Condition 11- Surface Water Drainage Design

Application No: **CM/11/21/DOC**

Registered: 5th March 2021
Site Address: Scyld Horsemere Green Lane Climping BN17 5QZ
Description of Works: Approval of details reserved by condition imposed under CM/21/19/PL relating to conditions 11-surface water drainage scheme, 12-discharge of flows to water courses or for the culverting, diversion, infilling or obstruction of any water course on or adjacent to site & 13-maintenance and management of surface water drainage system.

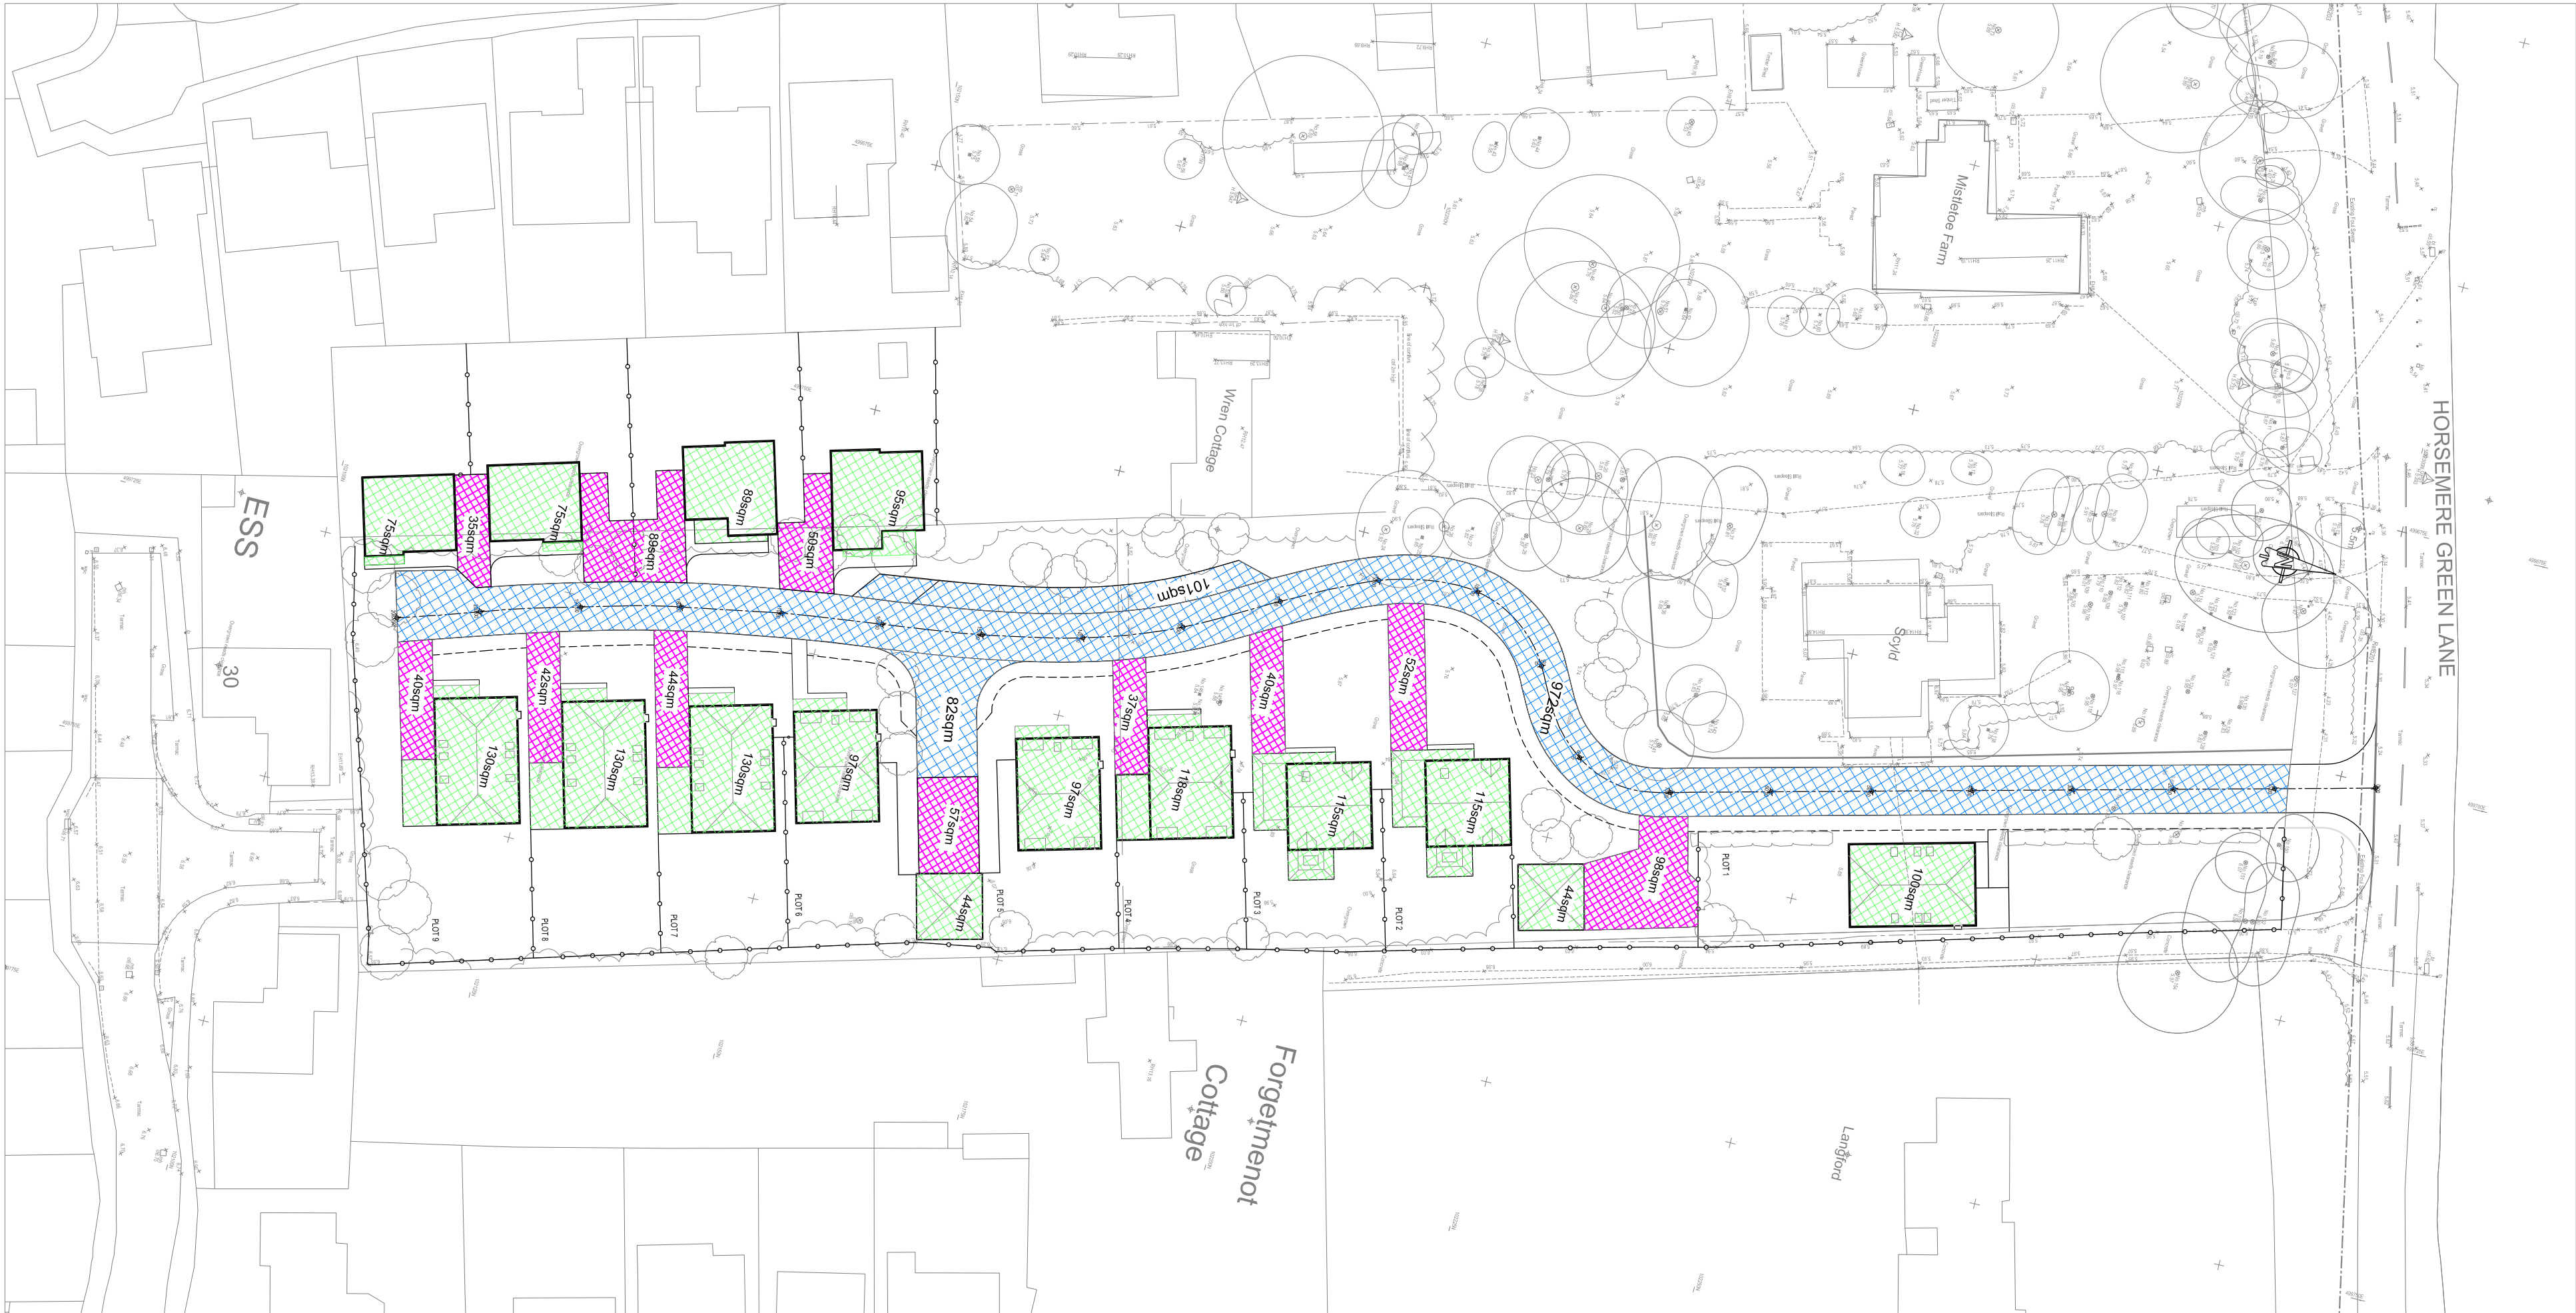
2. The impermeable areas plan appears to use an old layout, not the latest layout as approved under CM/55/20/PL. Please provide an updated impermeable areas plan. Updated plan attached to be read alongside the new calculations / drainage modelling. *Okay, point closed.*

DRAINAGE GA

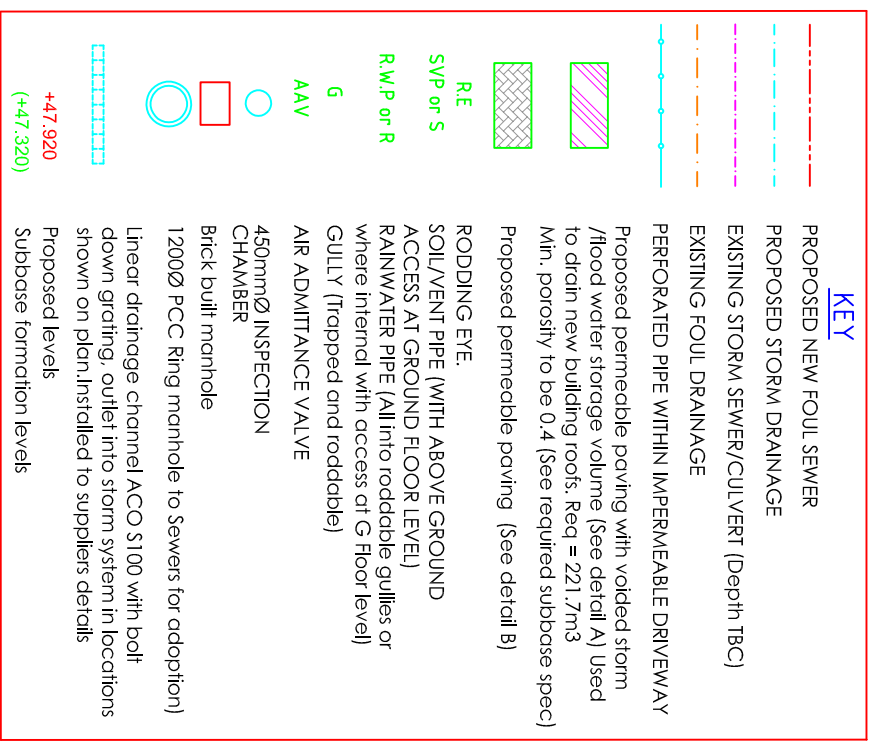
4. Please detail finish and formation levels of permeable paving on plan. These are shown in the detailed sections but have also been added to the plan. *Please detail on driveways.*

6. Please detail all pipe diameters and falls on plan. Plan updated. *Please detail pipes in permeable paving driveways.*
7. No connections are shown to/ from the permeable car park areas. We have now shown a connection into the storm drainage system.

DETAIL 1: TYPICAL SECTION SHOWING NEW ENTRANCE AND EXISTING HIGHWAY WITH NEW CULVERT

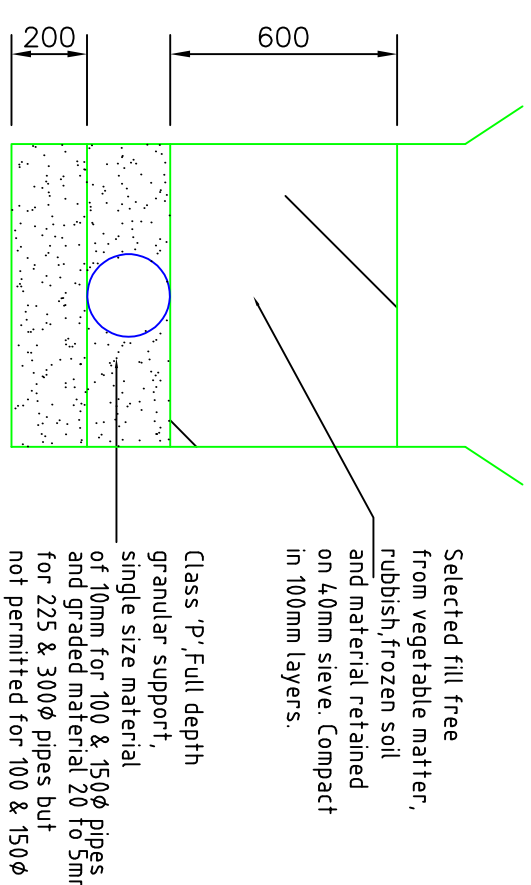
1. Please supply further details of the proposed culvert, i.e. diameter, invert level, and construction details- including headwalls. We have put more information on the drawing on the details drawing. *Two sets of drainage details sheet 2 have been provided, please confirm which version should be reviewed.*
2. It is stated on the plans that the culverting has been agreed, we do not believe this to be the case. Please supply evidence that an application for land drainage consent has been made for both the proposed culverting and outfall headwall. This has been applied for and we are issuing new information and the application is ongoing. Okay.

HEADWALL STRUCTURE FOR OUTLET PIPE

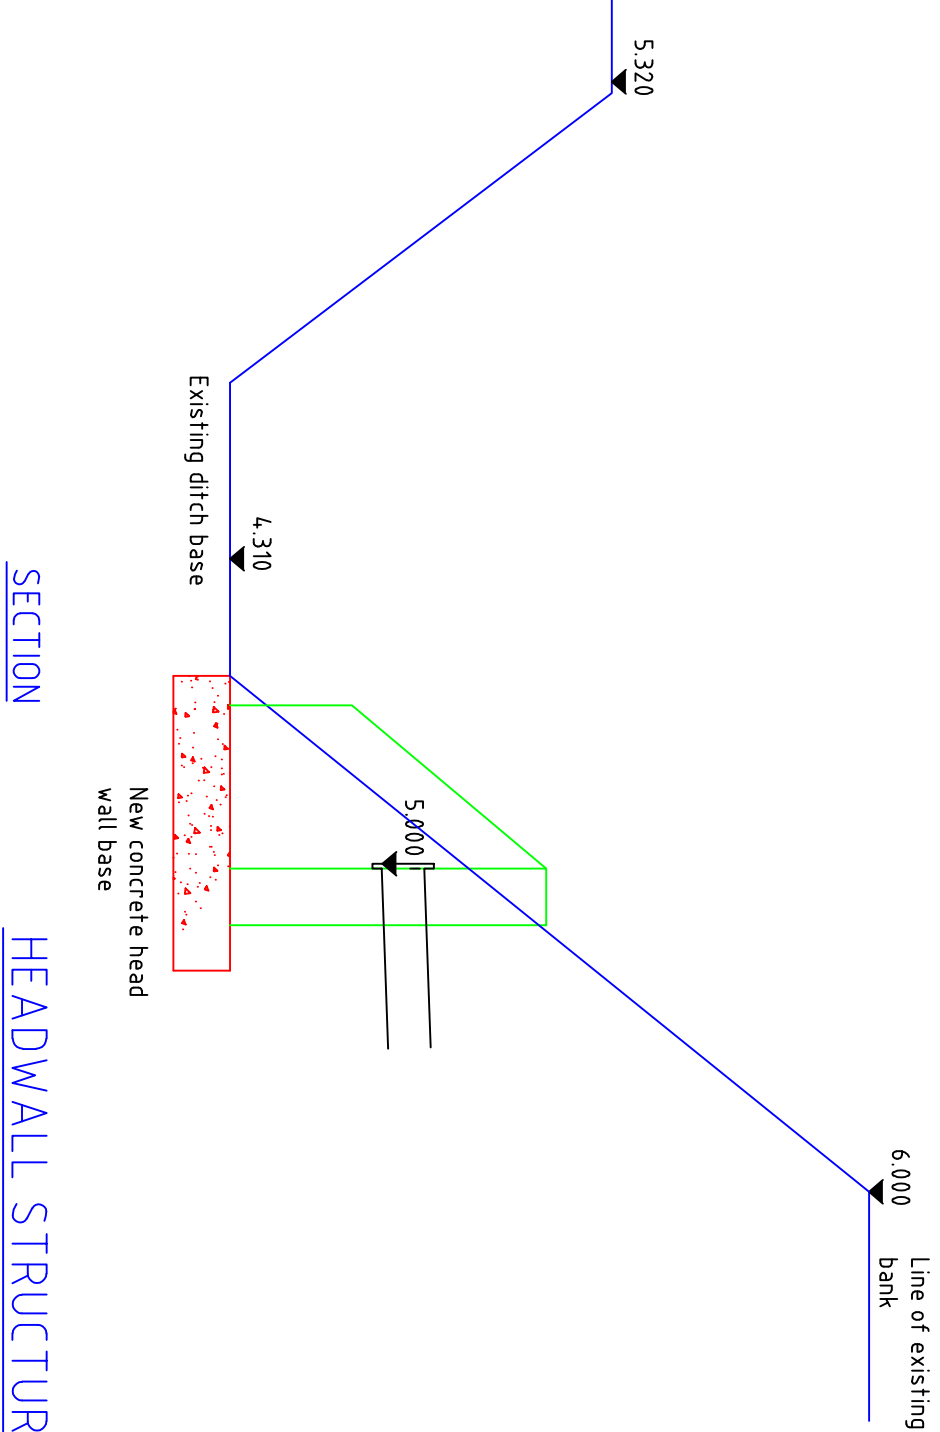
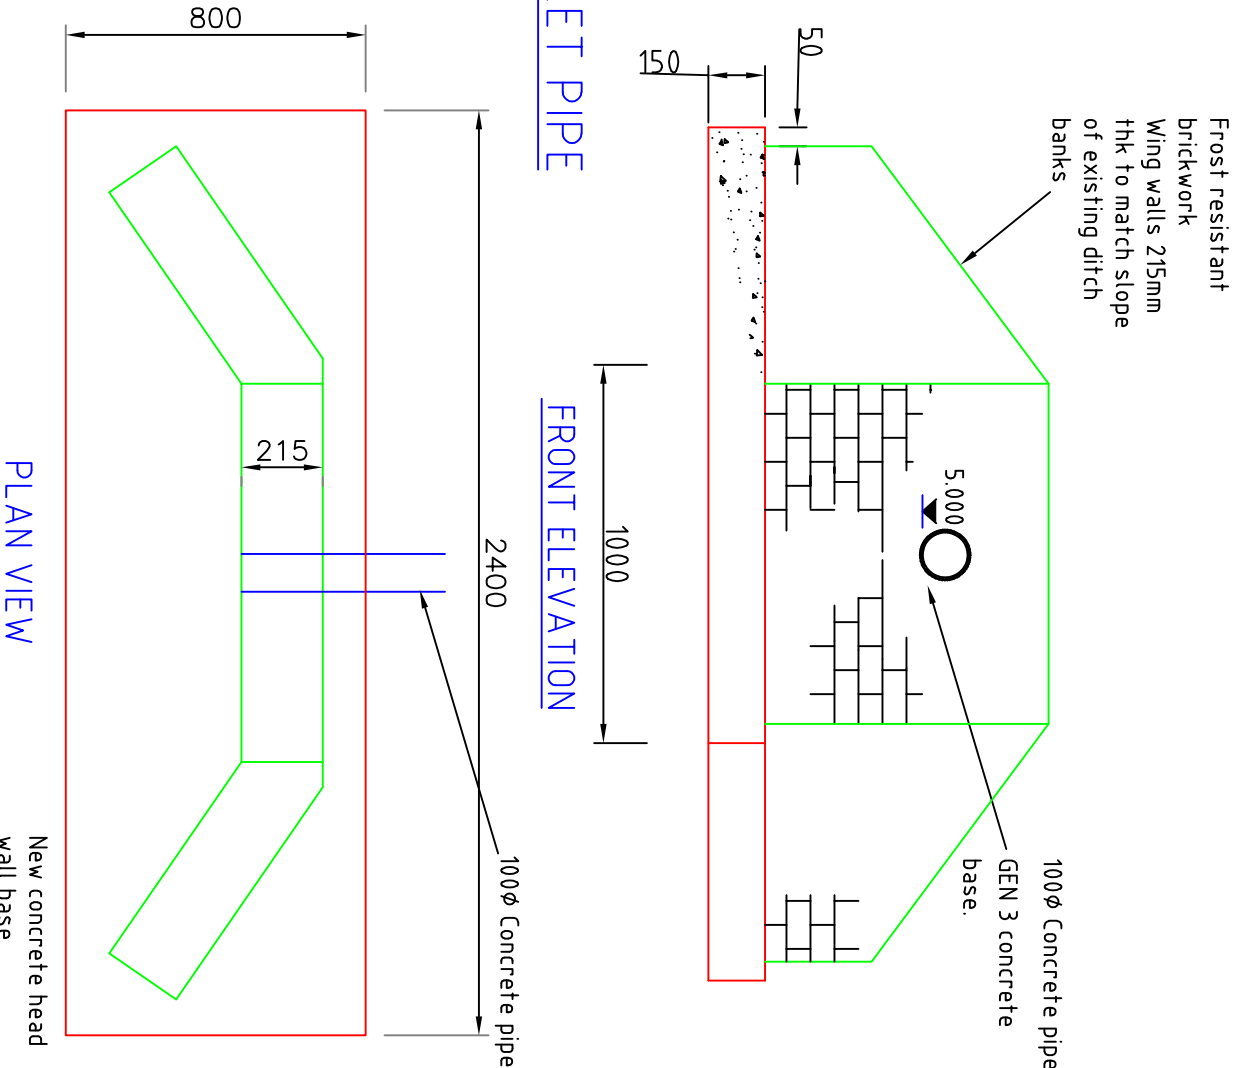
8. Please provide site specific construction detail drawings of the proposed headwall, this should include a plan and full cross section through the ditch. All headwall drawings should indicate existing bed level, and top of bank level. Detail updated. *Two sets of drainage details sheet 2 have been provided, please confirm which version should be reviewed.*
